Case Officer: Katherine Daniels

Applicant: Great Lakes UK Limited

Proposal: 1. Introduction of ventilation grilles above all guestroom windows;
2. Reduction of brick plinth to back of house areas of waterpark building;
3. Change of rear of hotel from stone to render retaining stone surrounds and sills; 4. Change of rear of hotel from stone to timber with timber surrounds and metal sills; 5. Change from stone plinth to buff brick plinth to back of house areas of waterpark building; 6. Change of buff brick from blue brick material around plinths; 7. Reduction of extent of plant screening above conference zone where plant is no longer present; 8. Reposition slow windows to eaves to raise them slightly; and, 9. Re-align windows above porte cochere (proposed as non-material amendment to 21/04158/F)

Bay B
Proposed Typical Bay Study

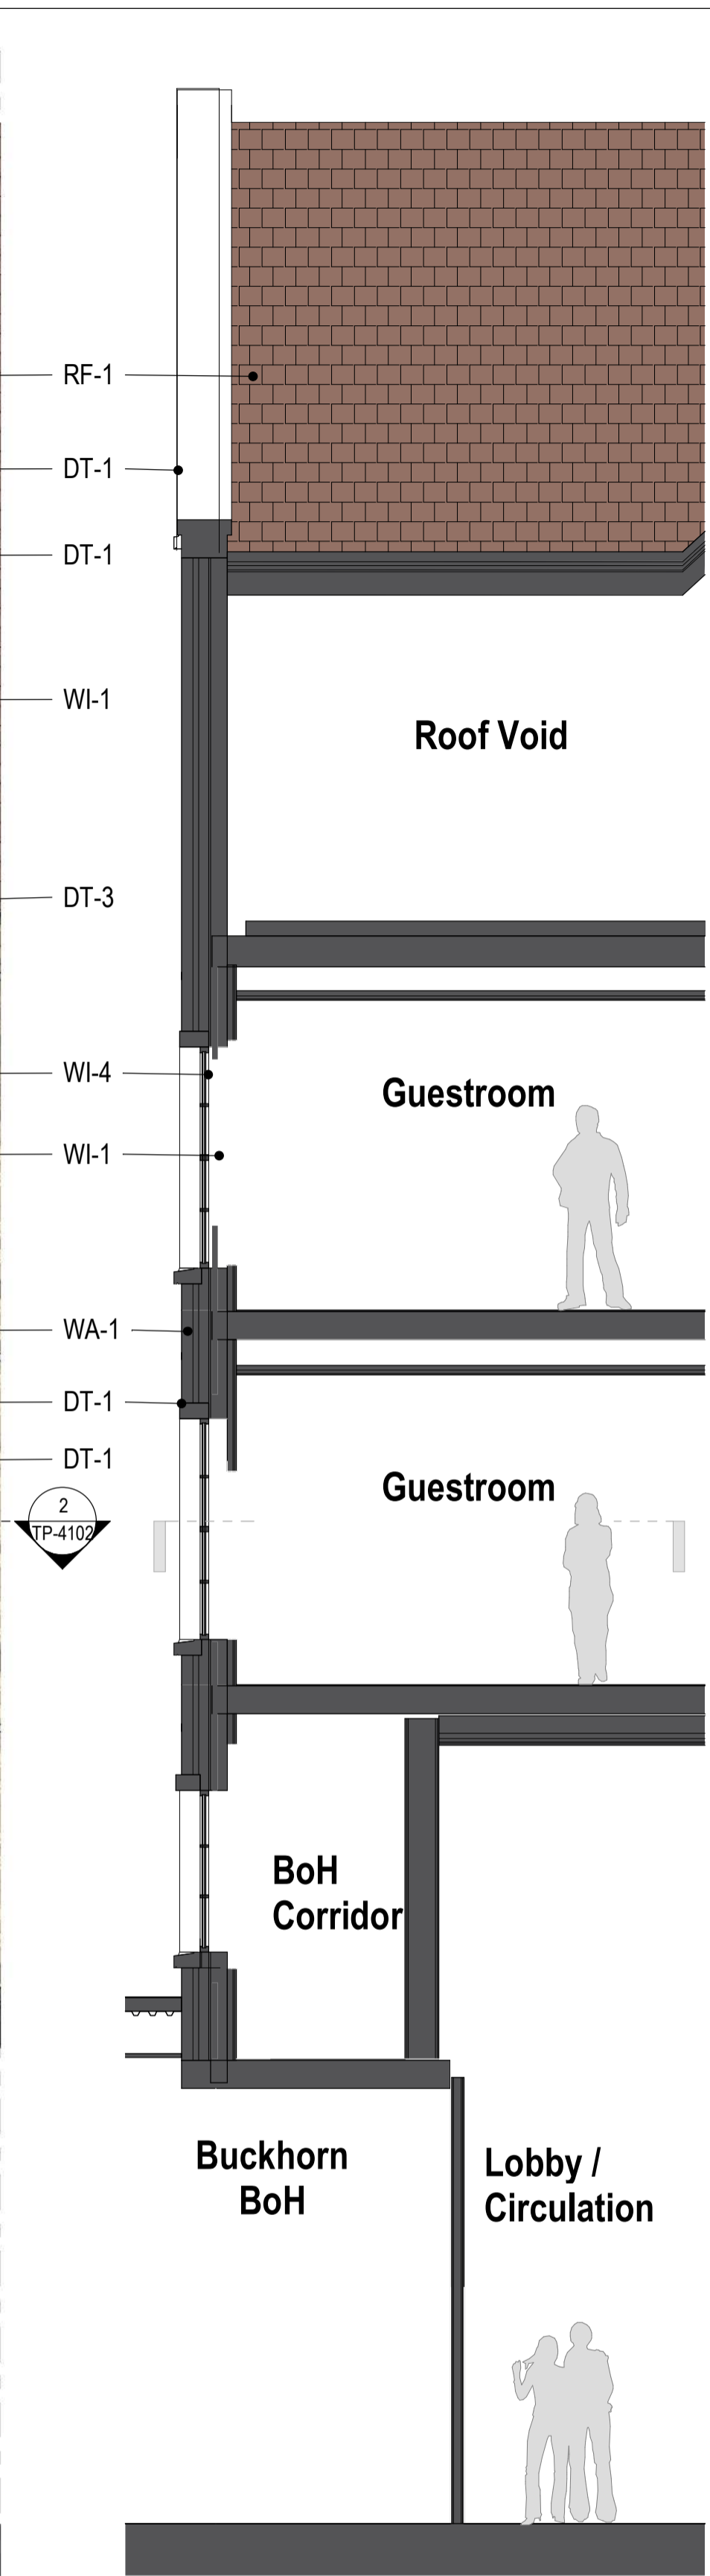
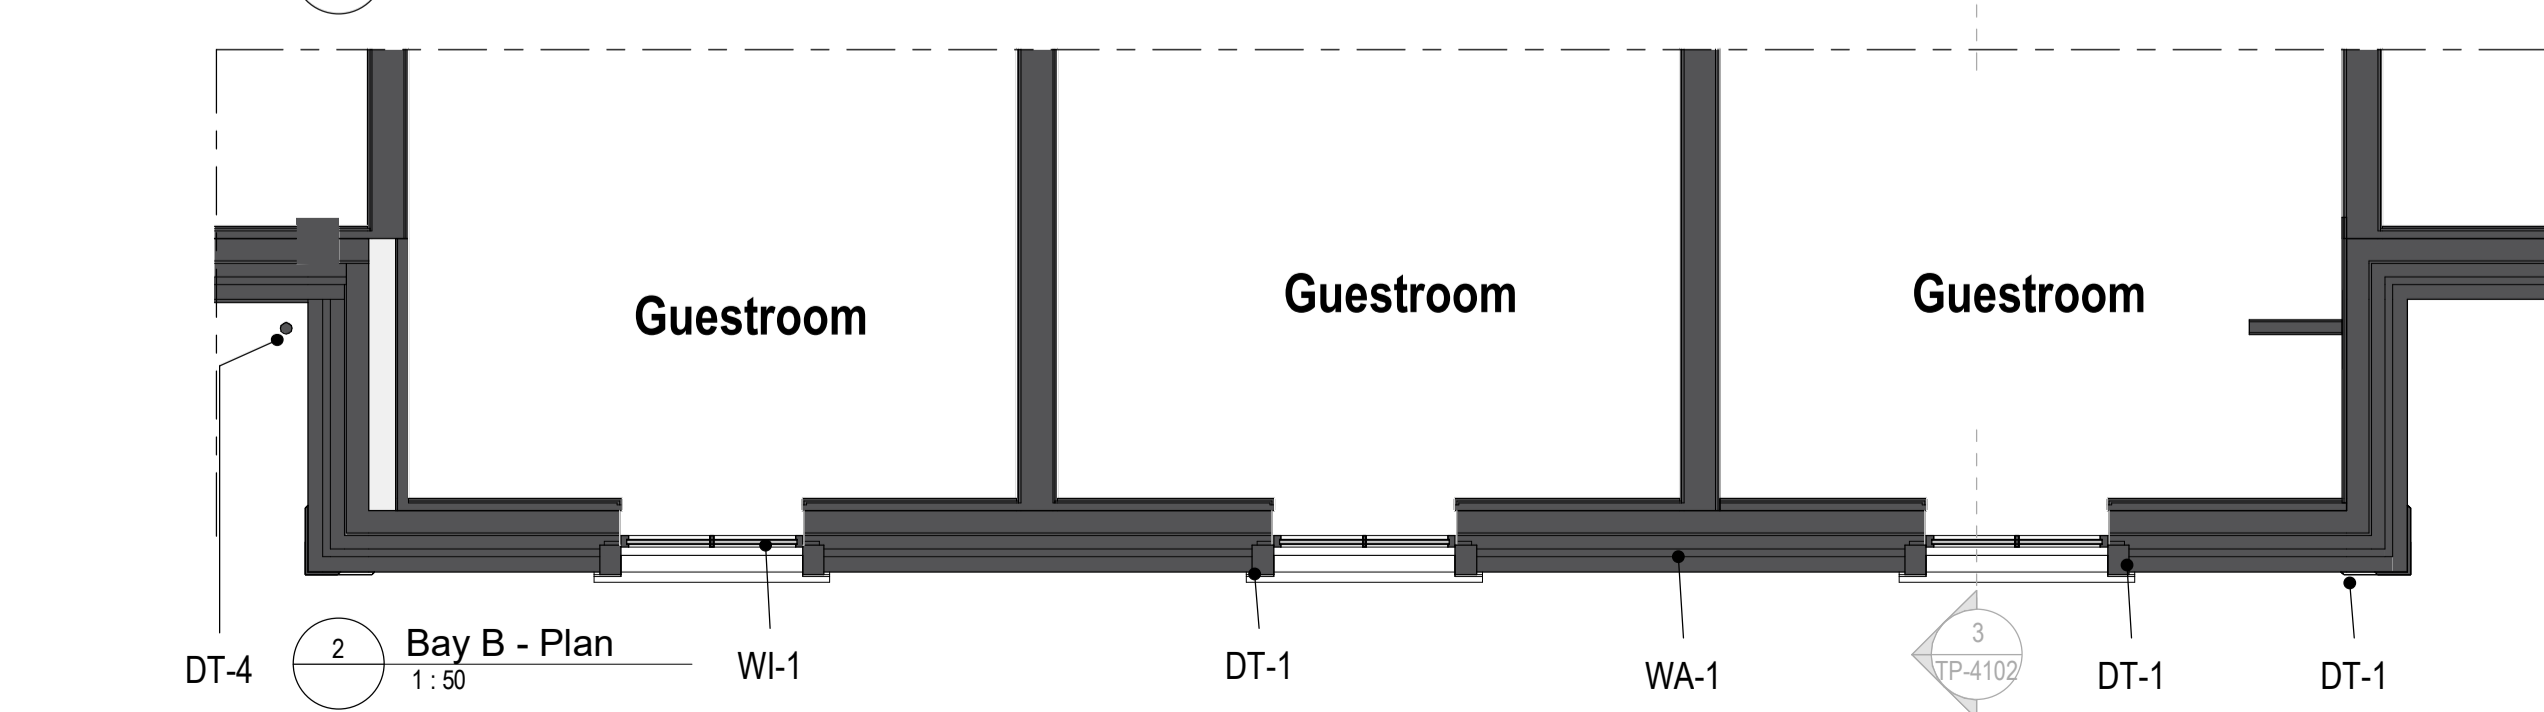
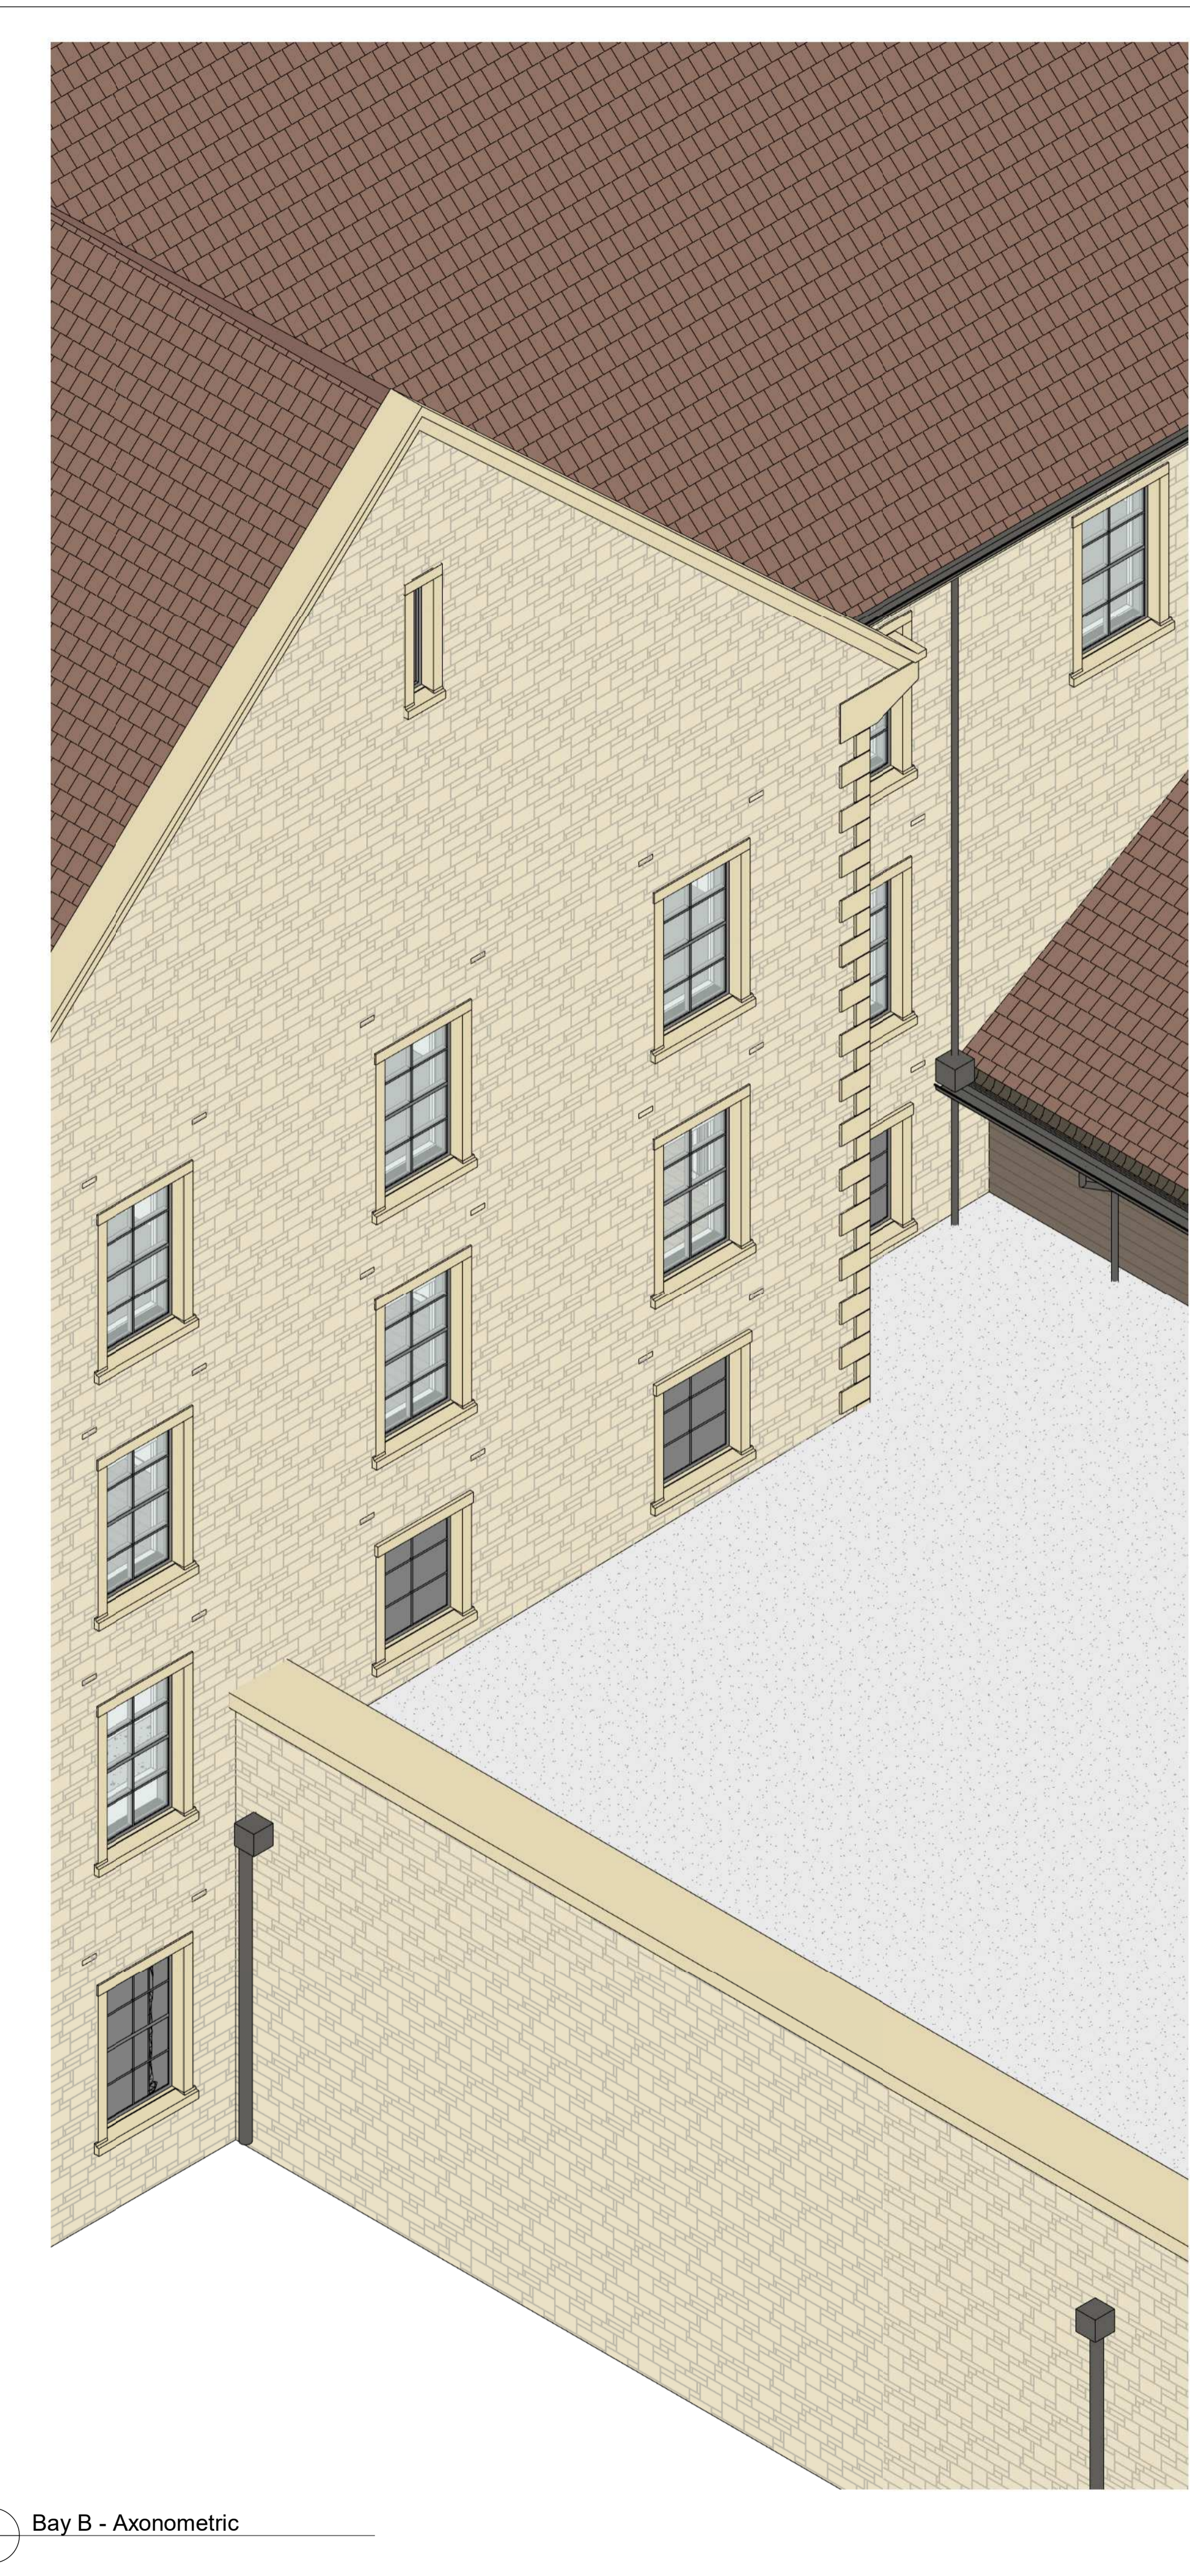
- 5.5. The introduction of ventilation grilles above the guestrooms is a change to the overall appearance of the building, however given the size of these grilles and the massing of the proposed building, it is unlikely to result in a material change to the overall character of the building. The character of the building will still remain.

- 5.10. The reduction of plant screening, is considered to be acceptable, and will not alter the overall development as a whole.
- 5.11. The reposition of the slow windows to eaves and raise them slightly again does not alter the overall design and appearance of the original scheme. The changes to these are minimal.
- 5.12. The windows are due to be re-aligned above the porte cochere changes are considered to be acceptable and does not affect the overall character and appearance of the building.
- 5.13. It is considered that some of the changes are unfortunate, however, overall, it is considered that the proposed alterations, given the overall size of the development will not alter the character and appearance of the proposed development. The alterations are considered to be non-material.
